Re: Transportation Impact Assessment – 5646 & 5650 Manotick Main Street Updated Site Plan Review

BT Engineering Inc. (BTE) has provided a Transportation Impact Assessment (TIA) for your proposed commercial development at 5646 & 5650 Manotick Main Street comprising of a Starbucks coffee shop and a 5-stall self-serve car wash. The latest TIA report submission was on October 16, 2023. The purpose of this letter is to comment on the recent changes to the site plan regarding transportation. The site plan under review, received on February 13, 2024, is appended to this letter.

**5646 & 5650 Manotick Main Street**  
 Vehicle Tracking – Car Wash

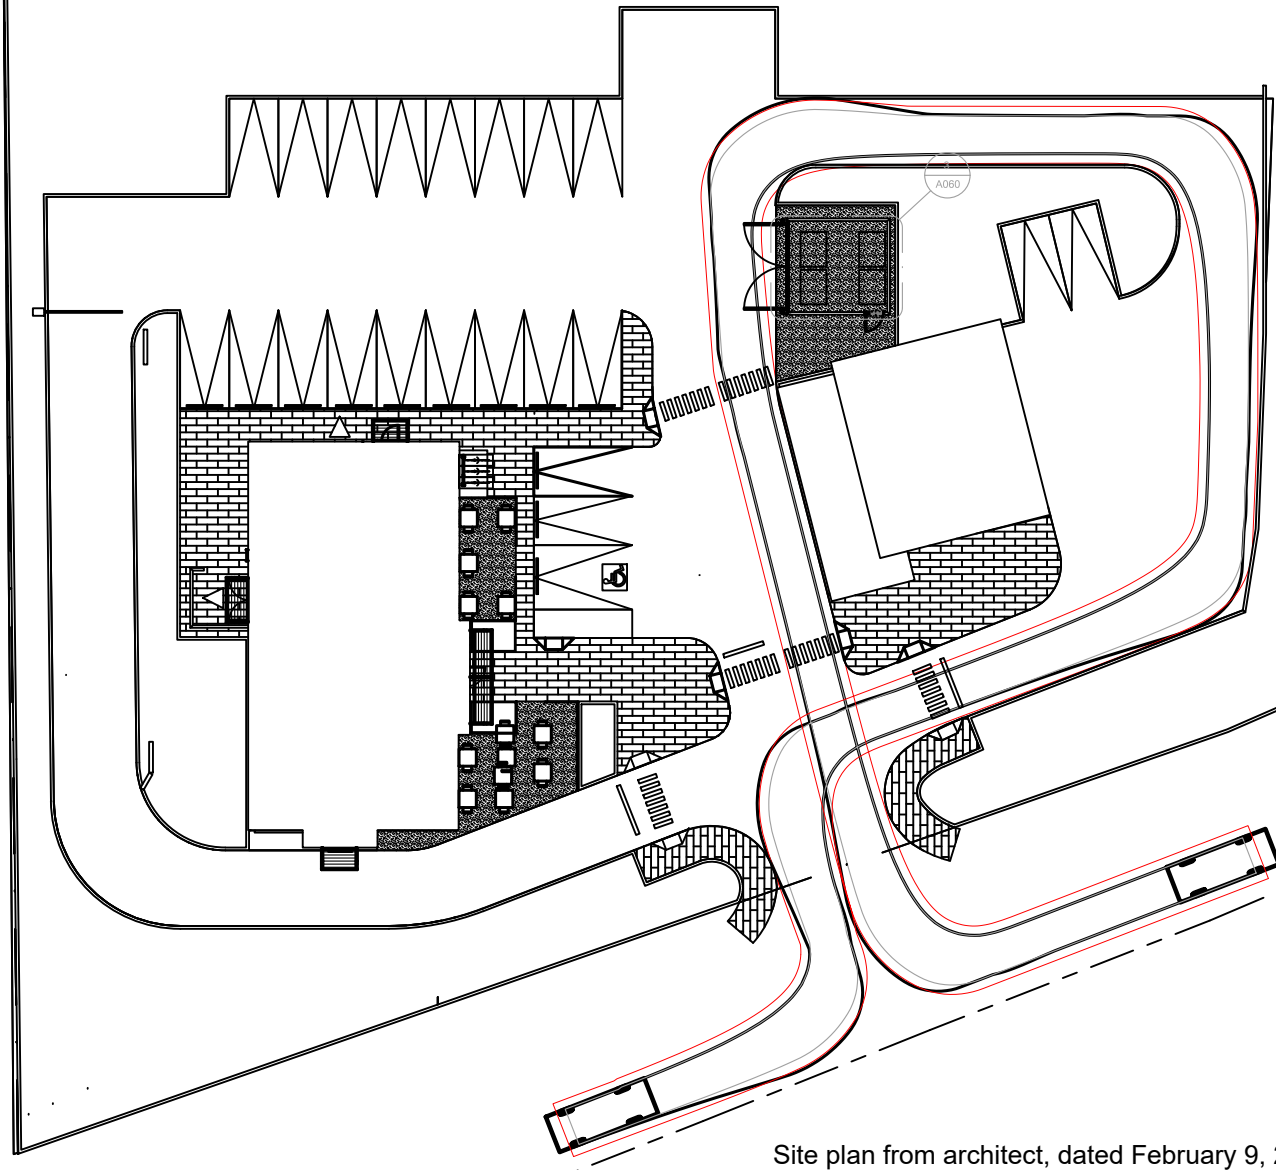
A vehicle tracking analysis has been conducted on the updated site plan and confirms that the drive-through lane and the car wash access lanes are wide enough to accommodate cars. Delivery vehicles will be able to drive toward the parking lot at the far end of the lot, then turn around and head back to the exit.
